Developer Services
Southern Water
Sparrowgrove House
Sparrowgrove
Otterbourne
Hampshire
SO21 2SW

R/243/14/PL

PLAN-007801

Proposal: Demolition of the existing buildings on the site and the erection of a new building containing 5No. 2-bed flats and 1No. 3-bed flat.
Site: 69 Broadmark Lane, Rustington, BN16 2HL.
R/243/14/PL

Drawing 6
Proposed Location &
Block Plan

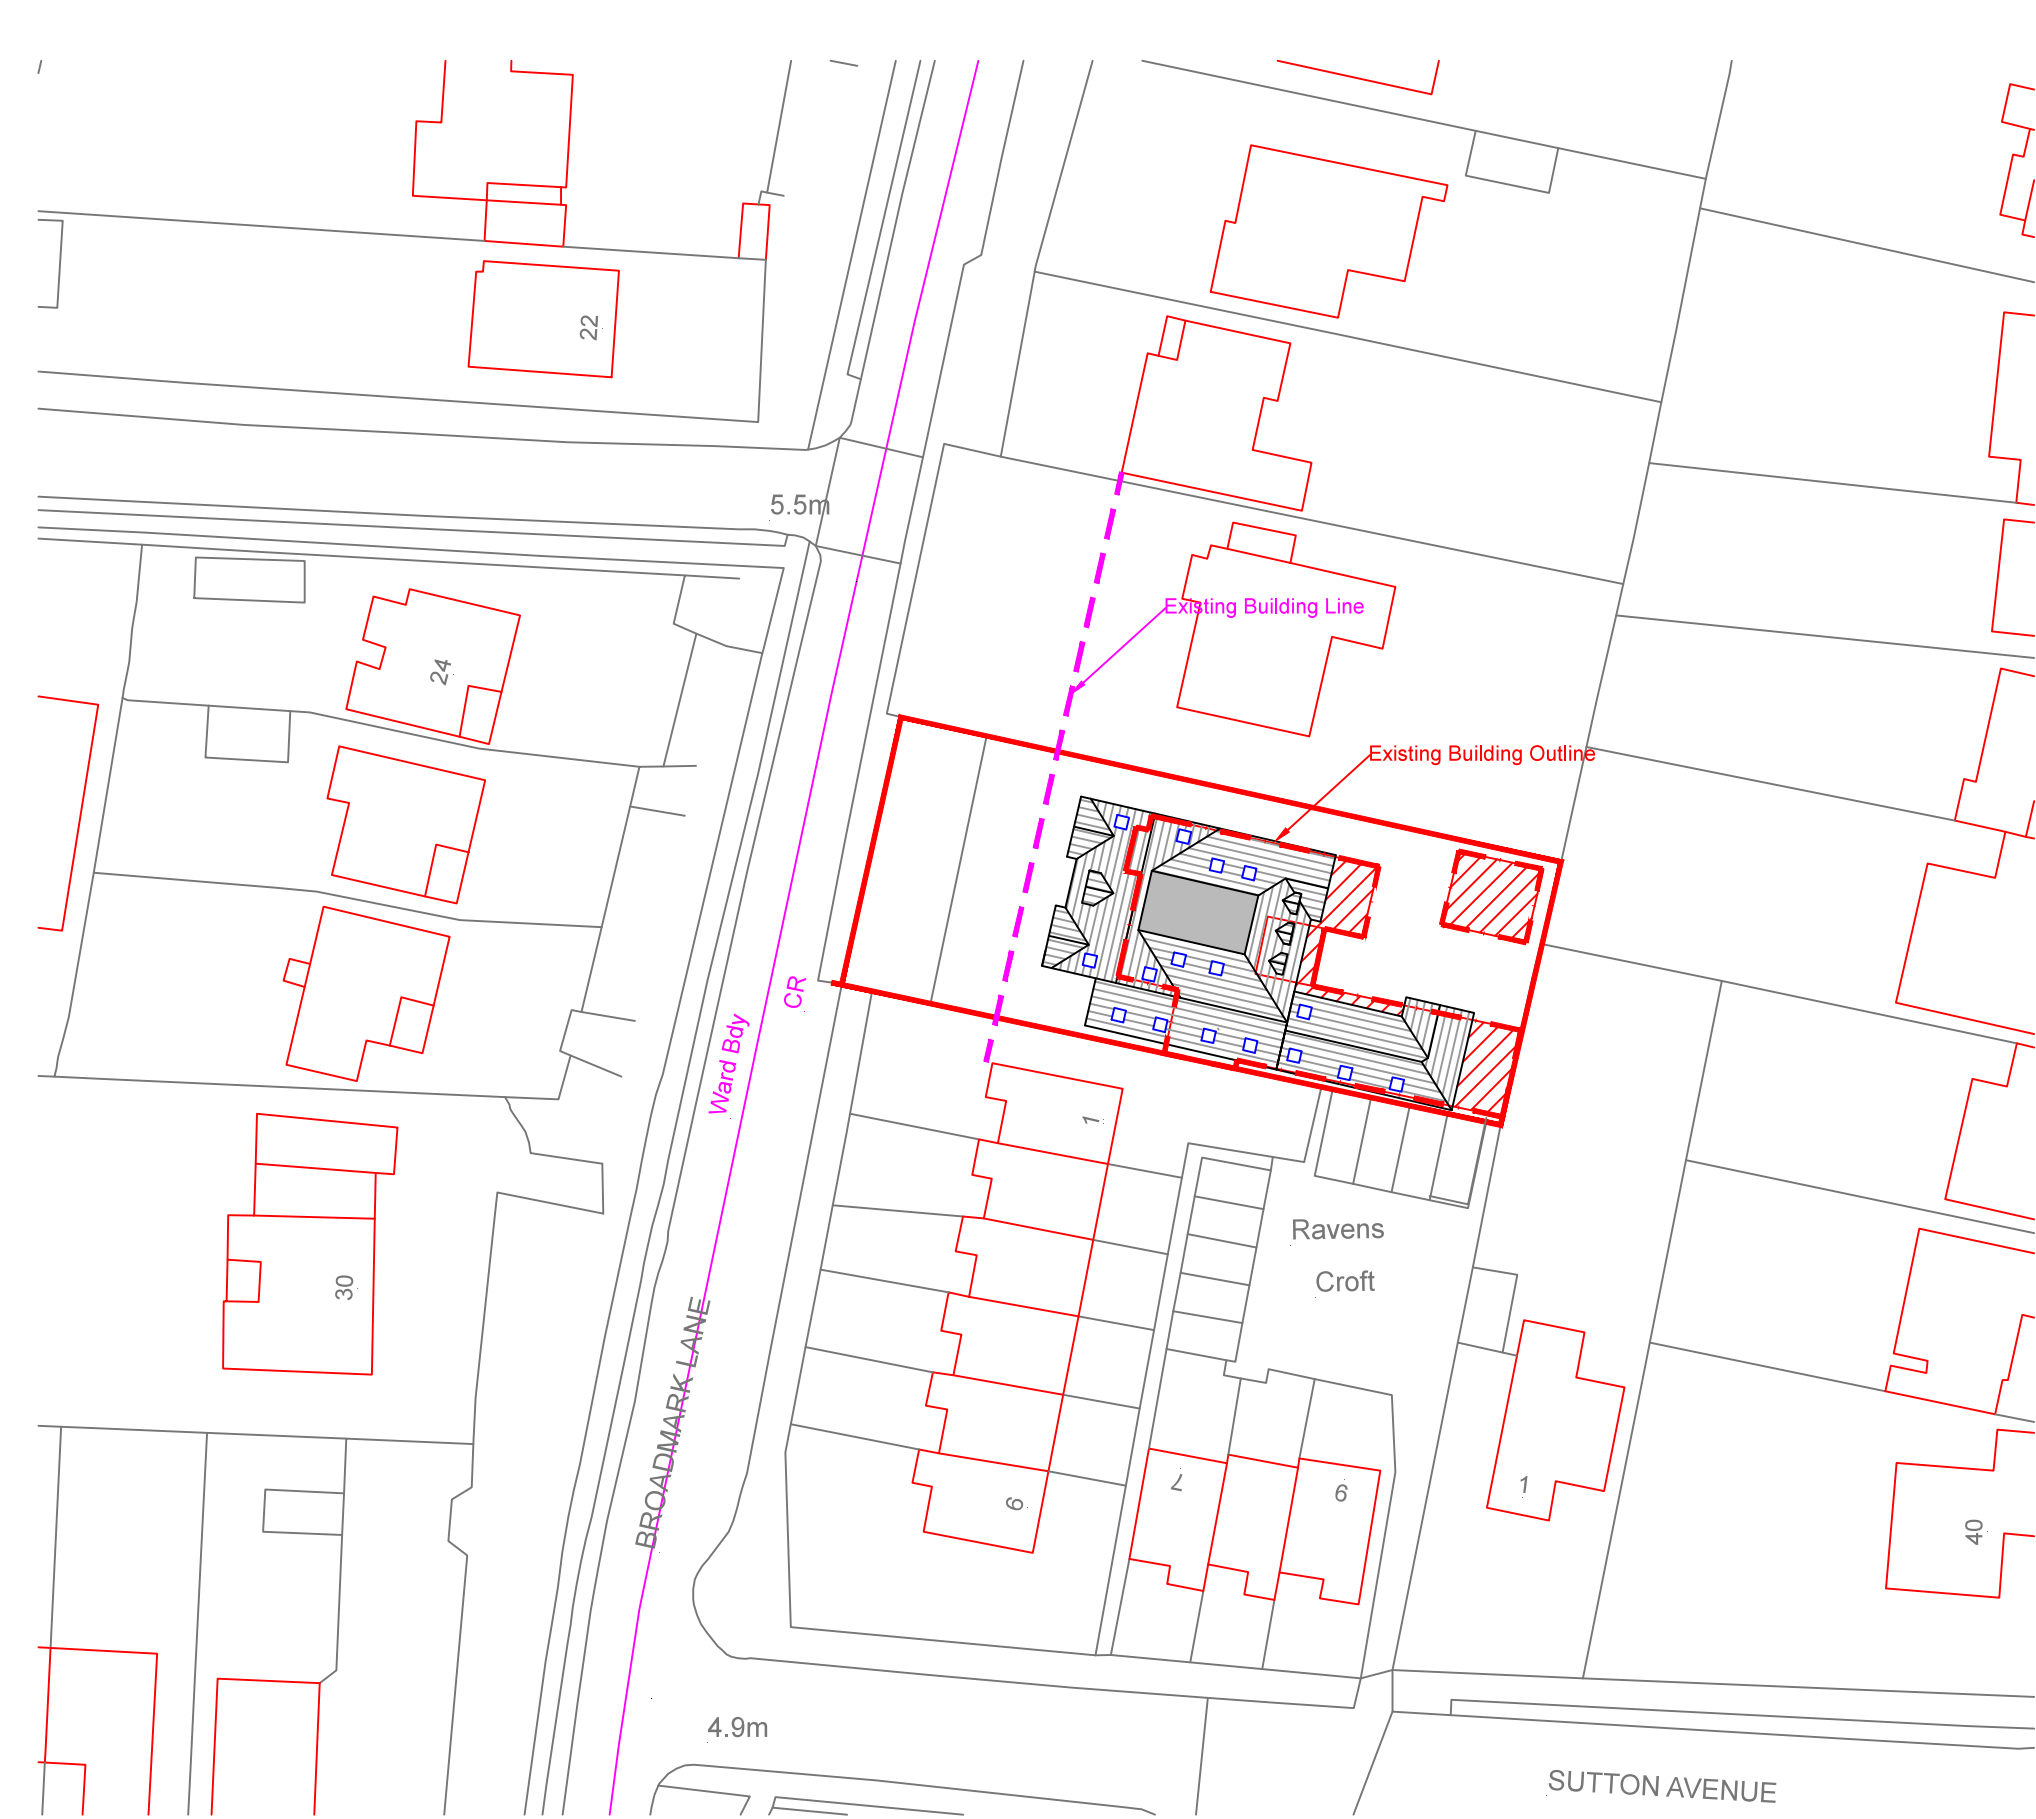
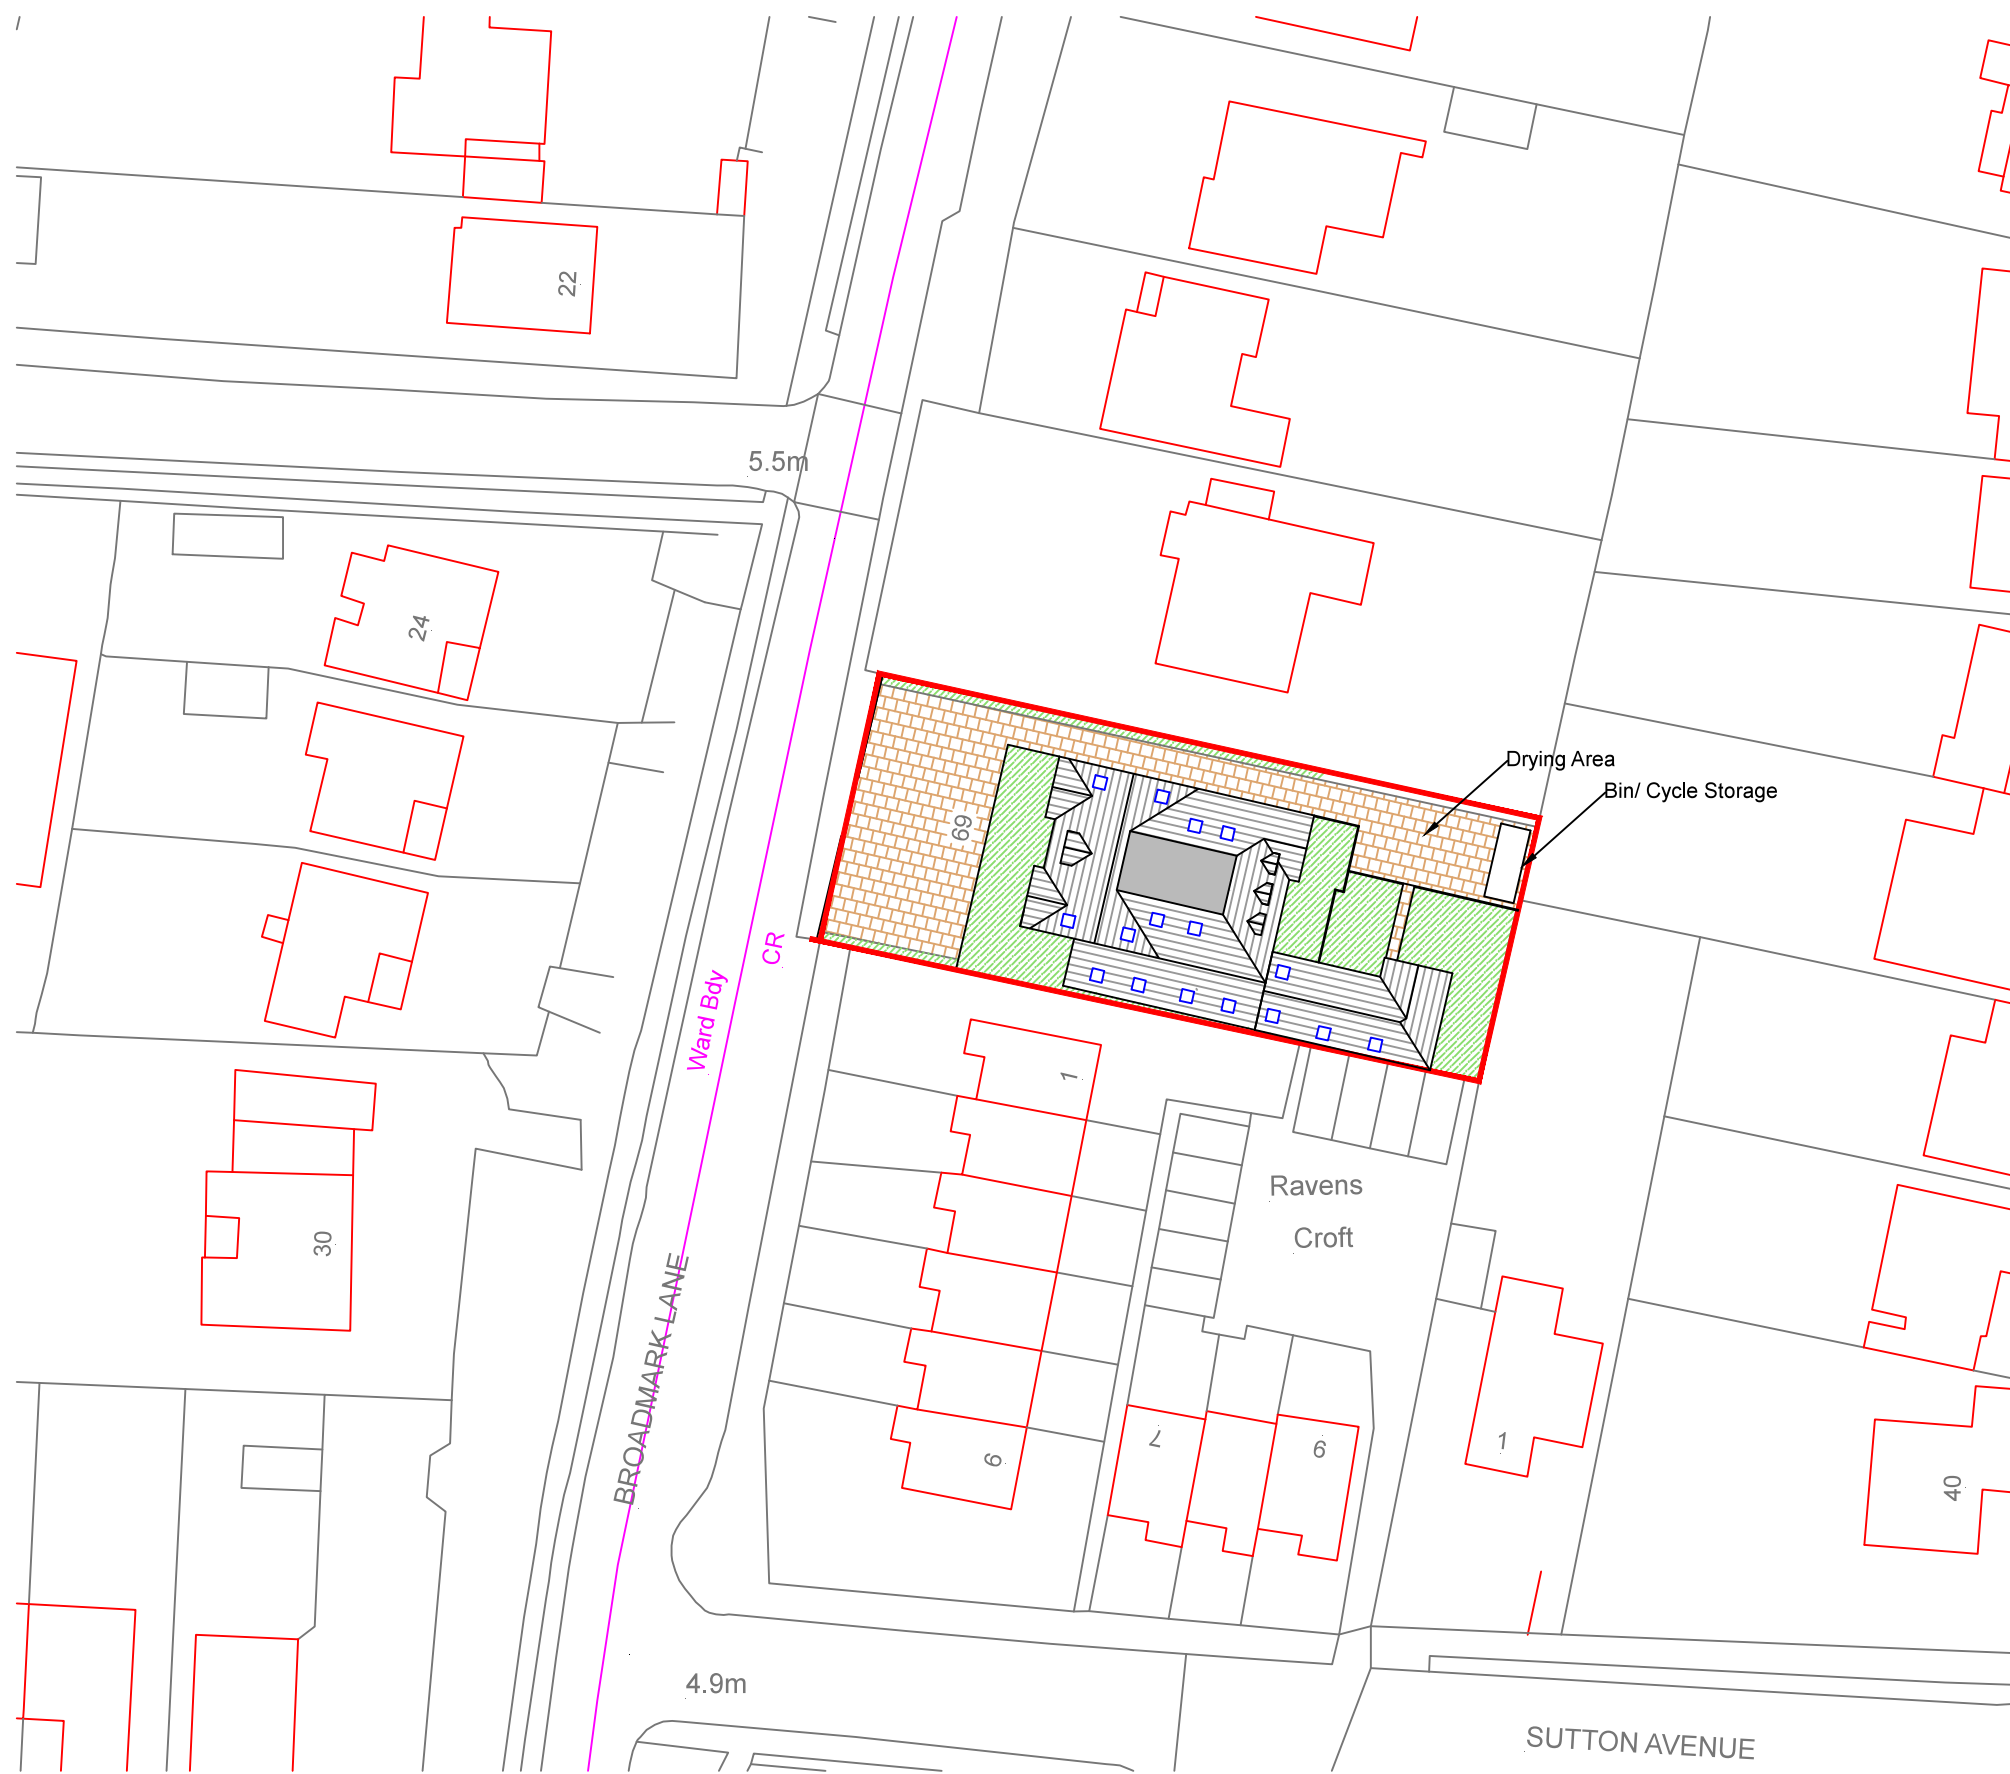
Please find attached a plan of the sewer records showing the approximate position of foul sewer crossing the site. The exact position of the foul sewer must be determined on site by the applicant before the layout of the proposed development is finalised.

1. The foul sewer requires a clearance of 3 metres either side of the sewer to protect it from construction works and allow for future access for maintenance.
2. No development or new tree planting should be located within 3 metres either side of the centreline of the public sewer
3. No new soakaways should be located within 5 metres of a public sewer.
4. All other existing infrastructure should be protected during the course of construction works.

Our initial investigations indicate that there are no public surface water sewers in the area to serve this development. Alternative means of draining surface water from this development are required. This should not involve disposal to a public foul sewer.

Alternatively, the applicant may wish to amend the site layout, or combine a diversion with amendment of the site layout. If the applicant would prefer to advance these options, items (1) – (4) above also apply.
